CITY OF ALBUQUERQUE

September 23, 2016

Re: Midtown Self Storage
4339 Cutler Ave NE
30-Day Temporary Certificate of Occupancy- Transportation Development
Engineer's Stamp dated 07-22-16 (H17D105)
Certification dated 09-21-16

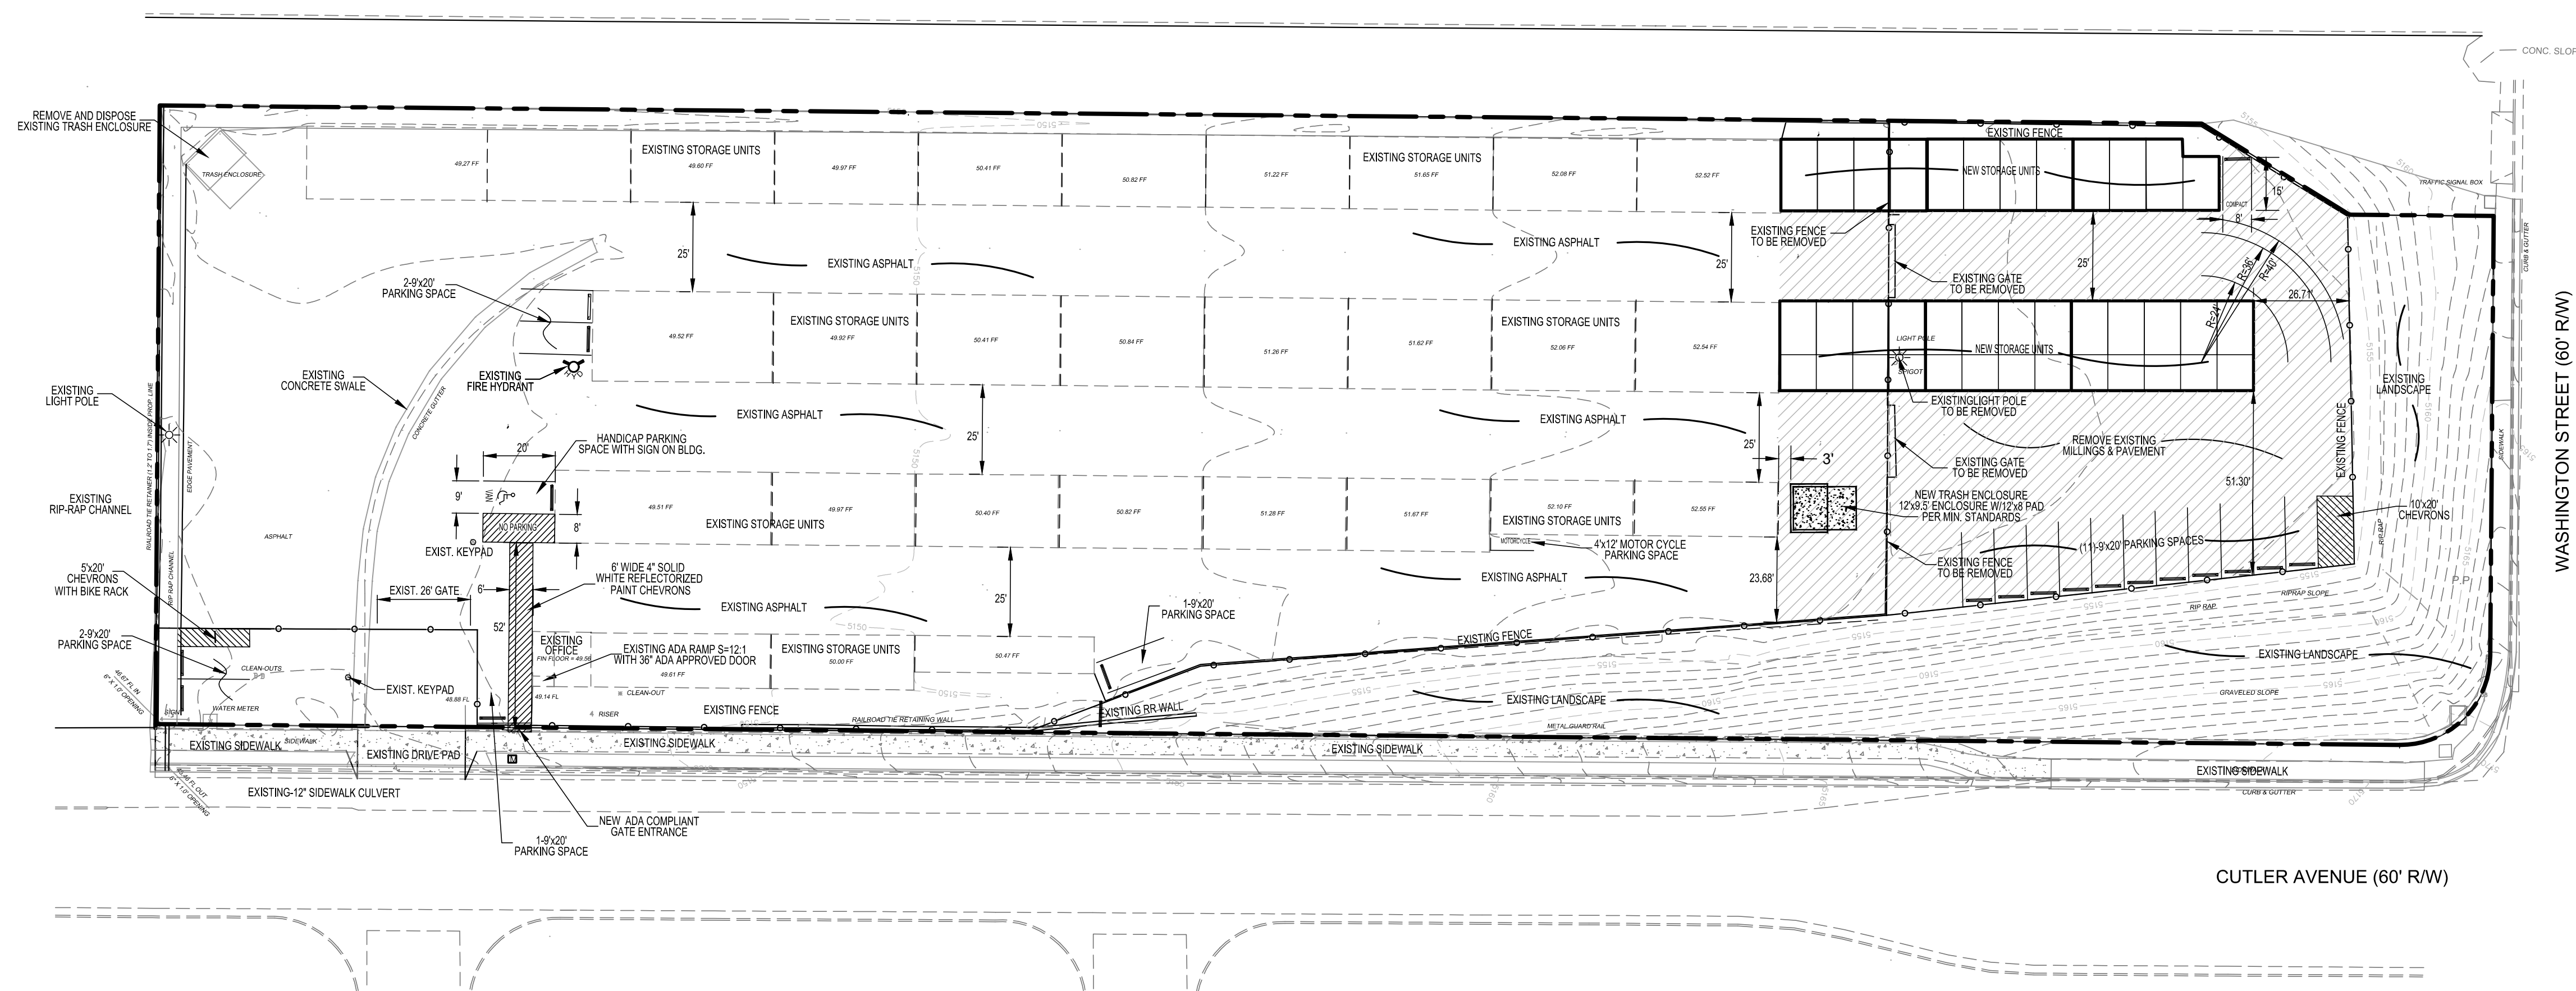
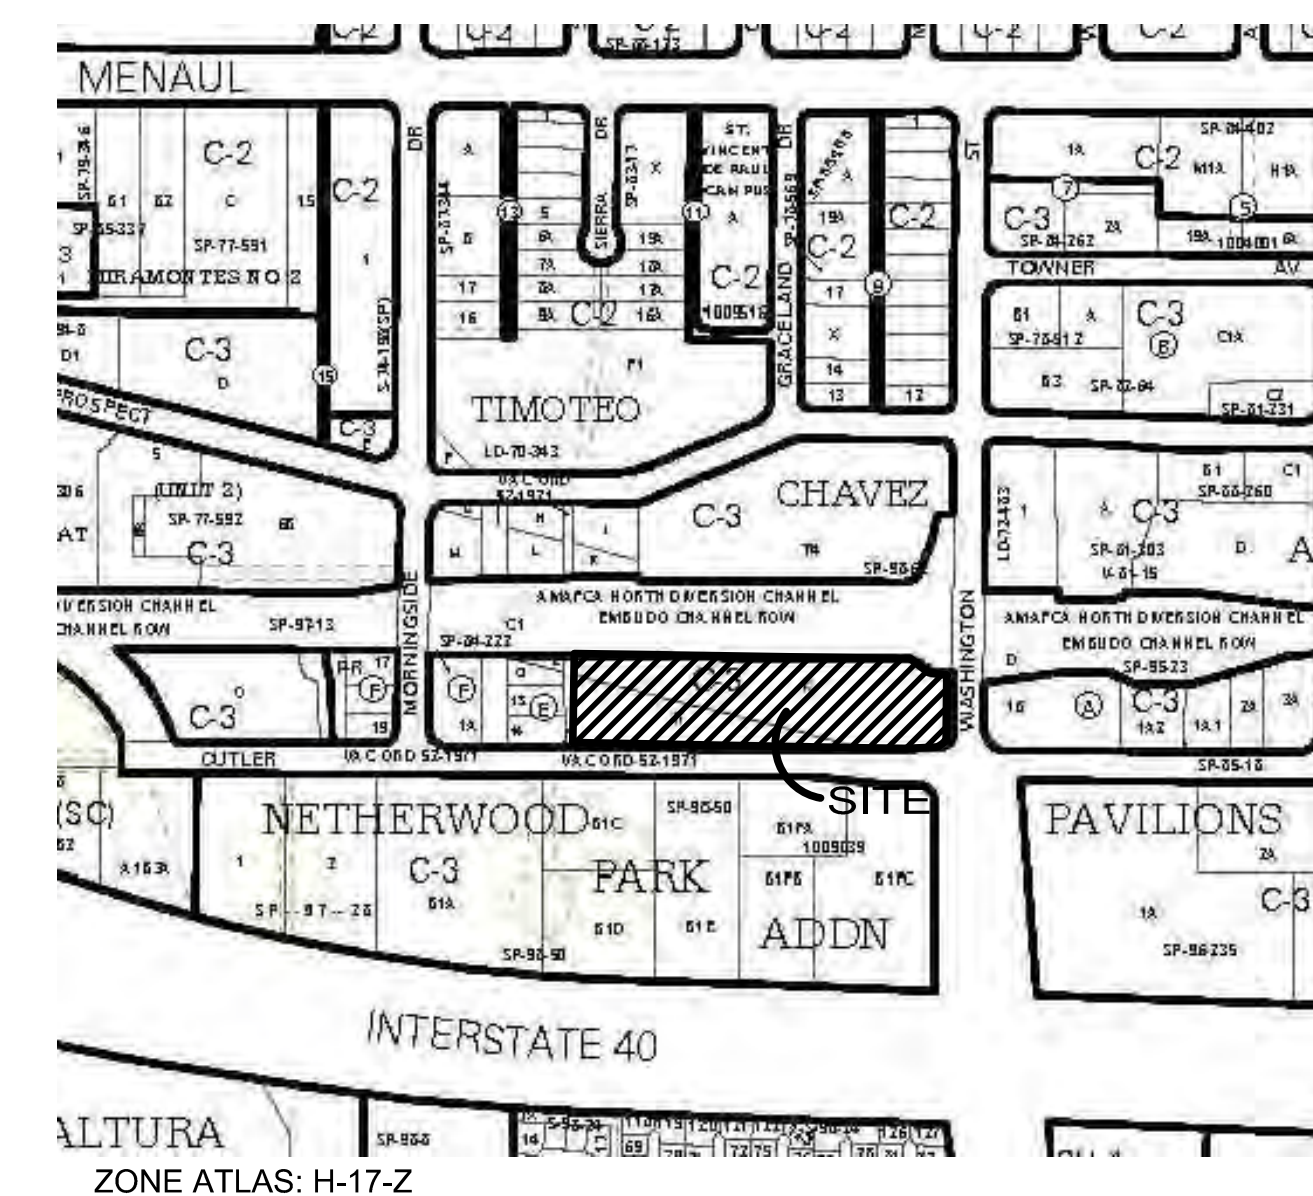
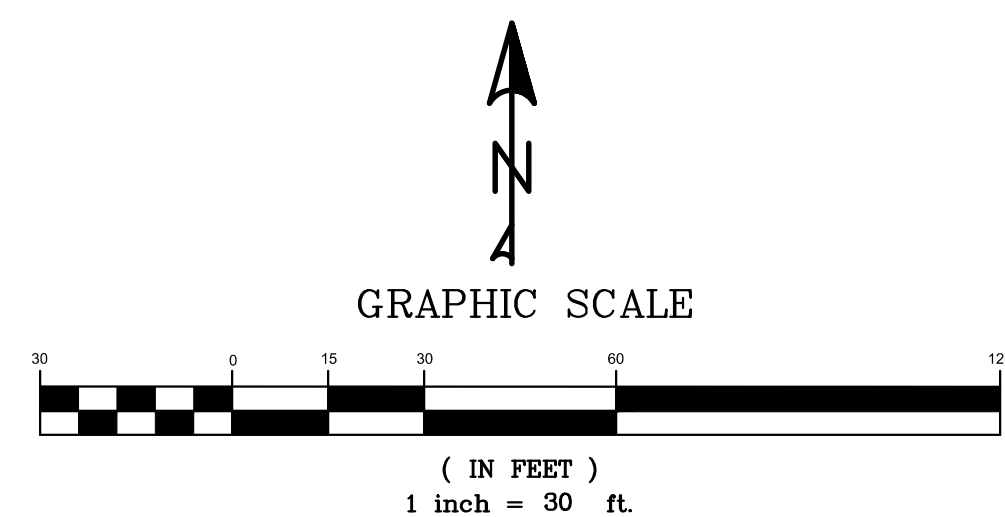
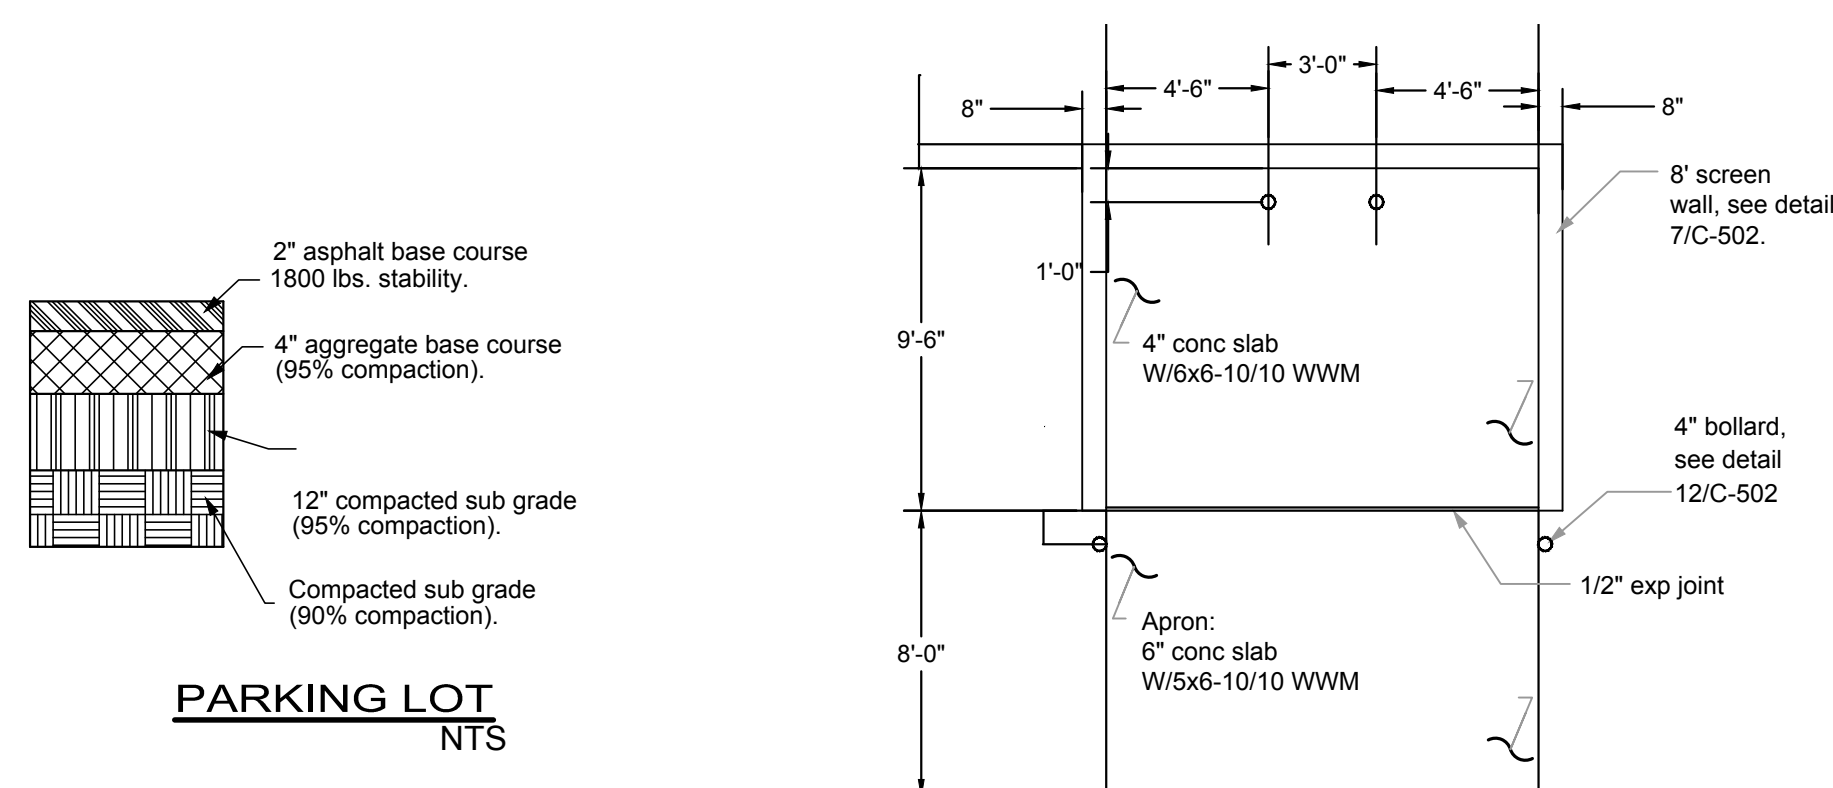
1. Per the zoning code, a 6 ft. wide ADA accessible pedestrian pathway is required from the public sidewalk to the building entrances. Please clearly show this pathway and provide details.
2. The approved TCL plan stamped and approved on 07-22-16 by Transportation must be the plan certified and submitted for Final TCL-CO.
